Our ref: 26/00093#94

Your ref: SSD-85362210

19 June 2026

Subject: Ebor Battery Energy Storage System

SHEET TITLE
PROPOSED INTERSECTION LAYOUT PLAN

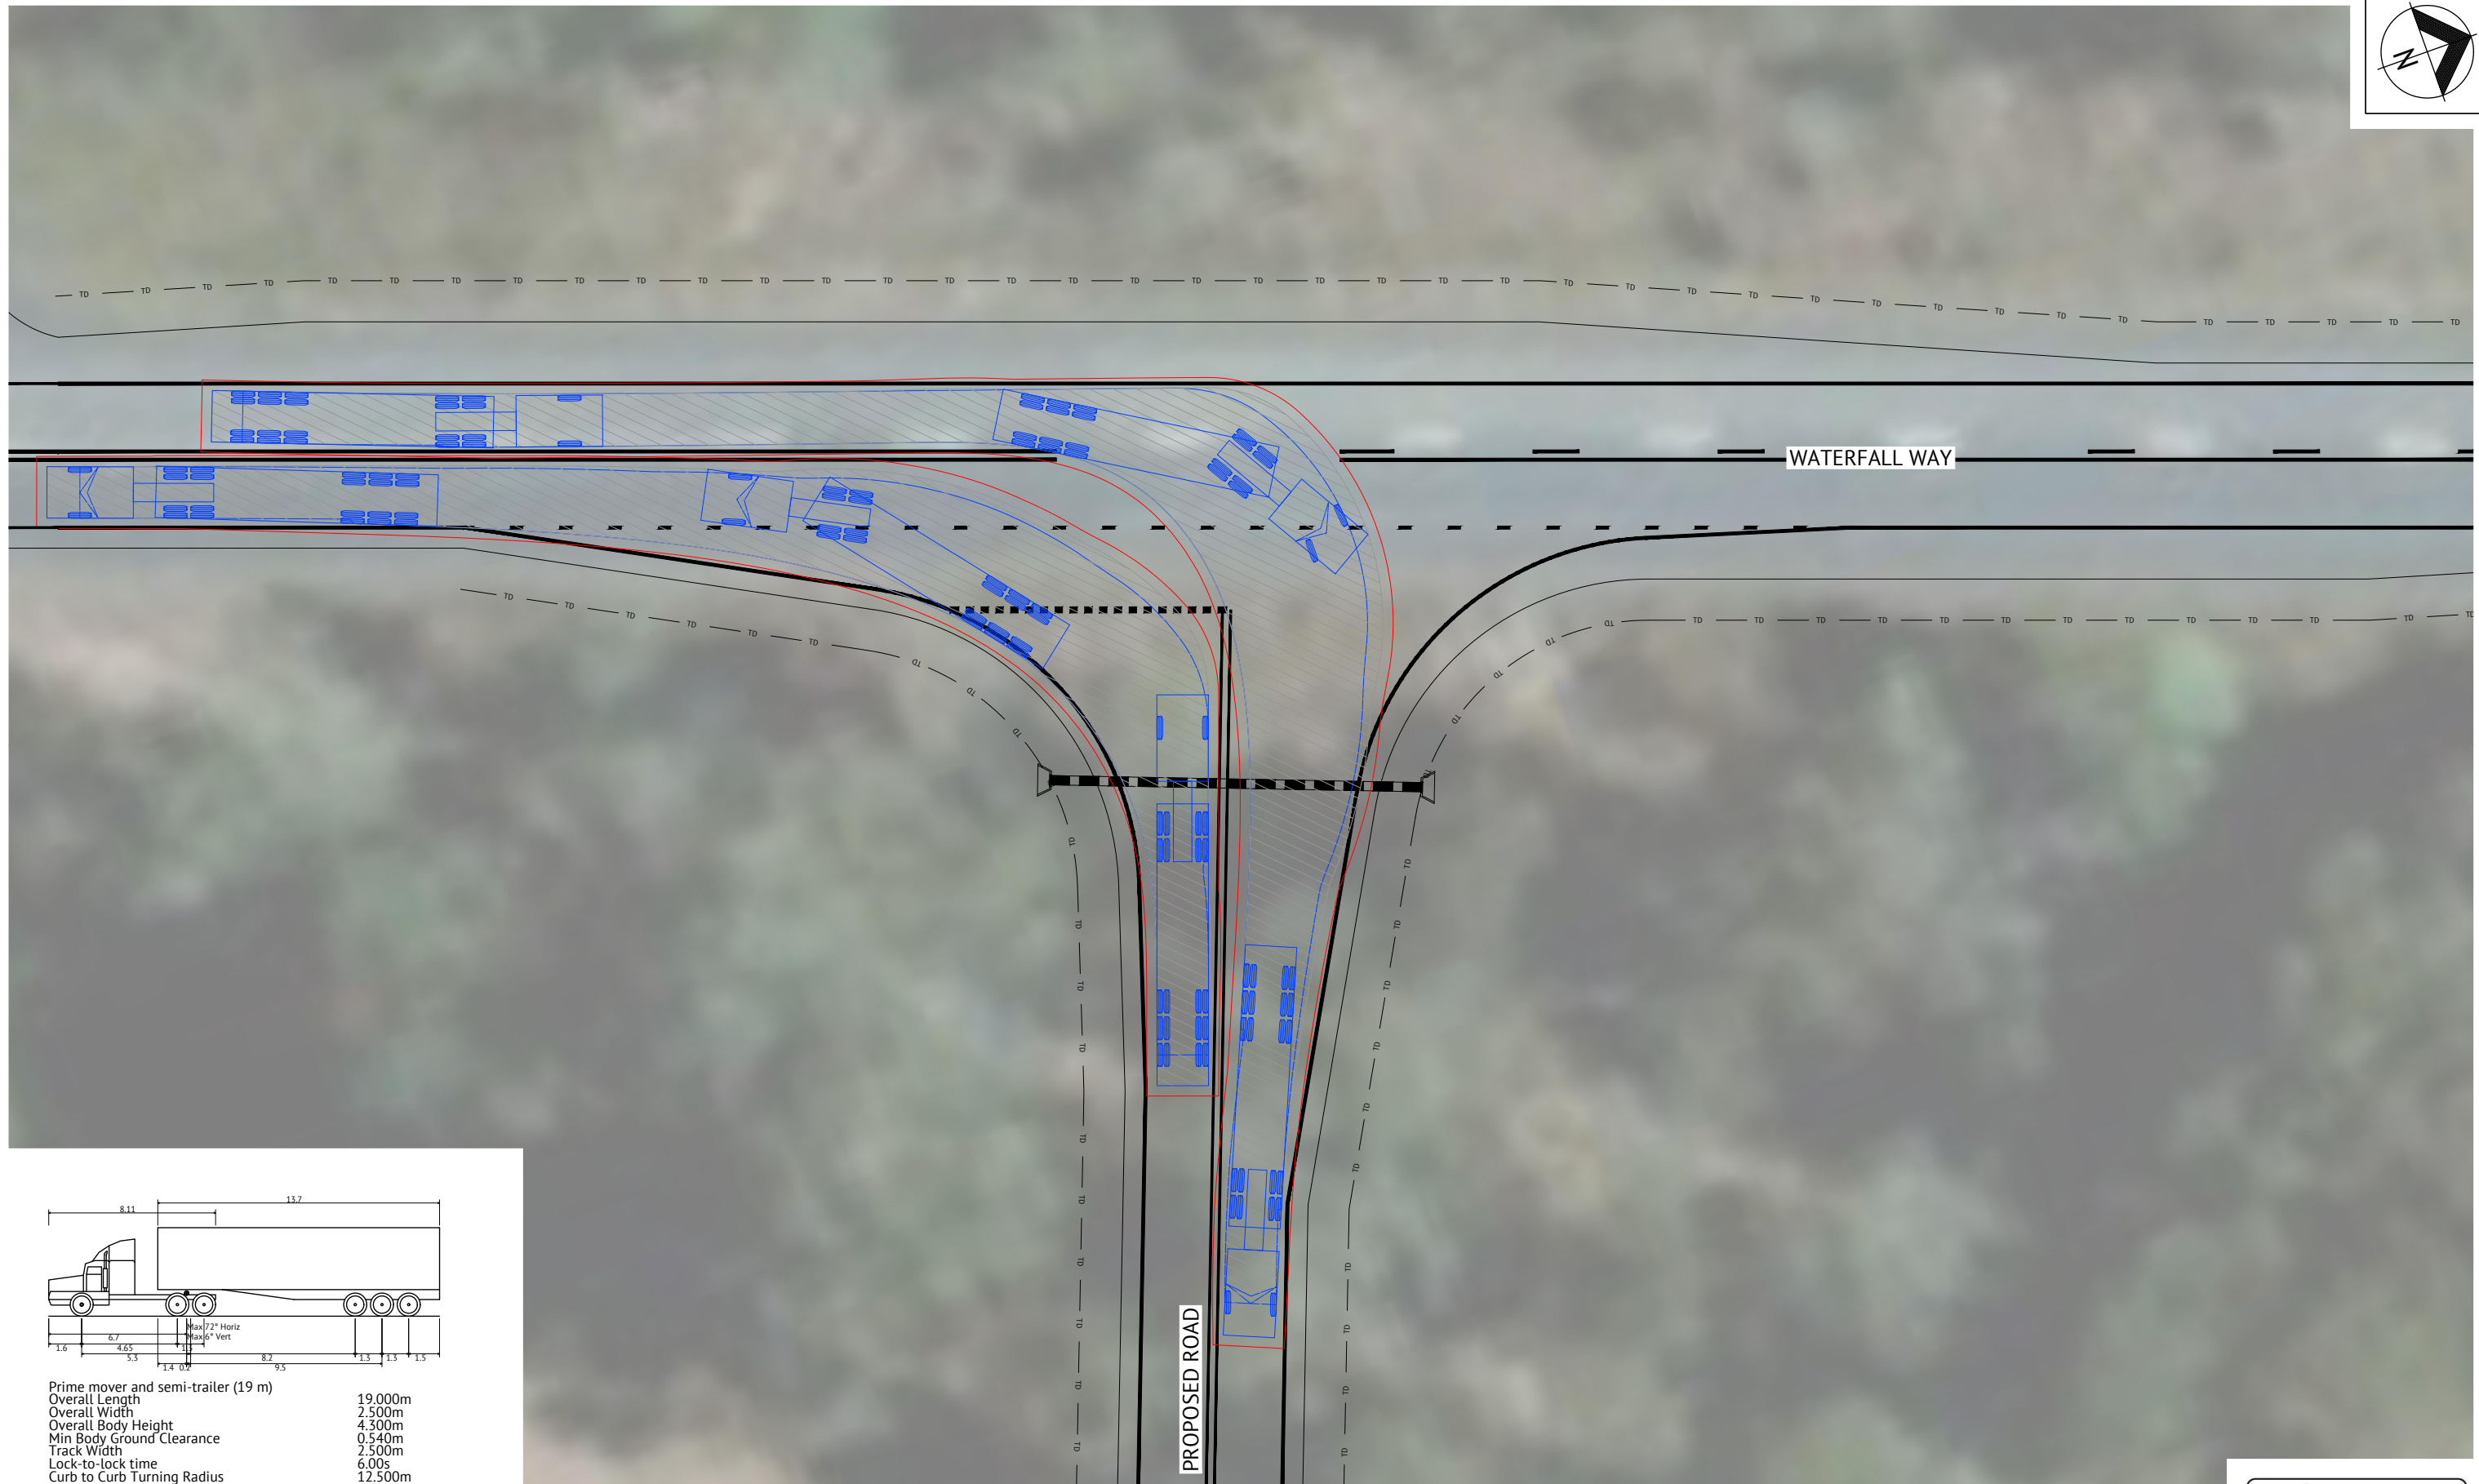
At this location the existing Waterfall Way formation does not align with the cadastral road corridor(s). It is the understanding of the Department that where Crown reserve boundaries are based on a registered diagram rather than road survey plan, the existing road formation becomes the road corridor to the same width as the cadastral road corridor (in this case approximately 18m width, with 9m either side of the existing road centreline).

Land outside this width in Lot 7024 DP 1117640 and Lot 7005 DP 111735 should be considered part of Crown reserve 30780. Proposed works to create a turning entrance that impinges on the Crown reserve will need to be authorised by the Department. Likewise, the proposed entrance track through the Crown reserves will require the authorisation of the Department. The proponent should apply for a Crown land licence as soon as possible to ensure requirements for referencing can proceed in a timely manner to issue the licence if the proposal is approved.
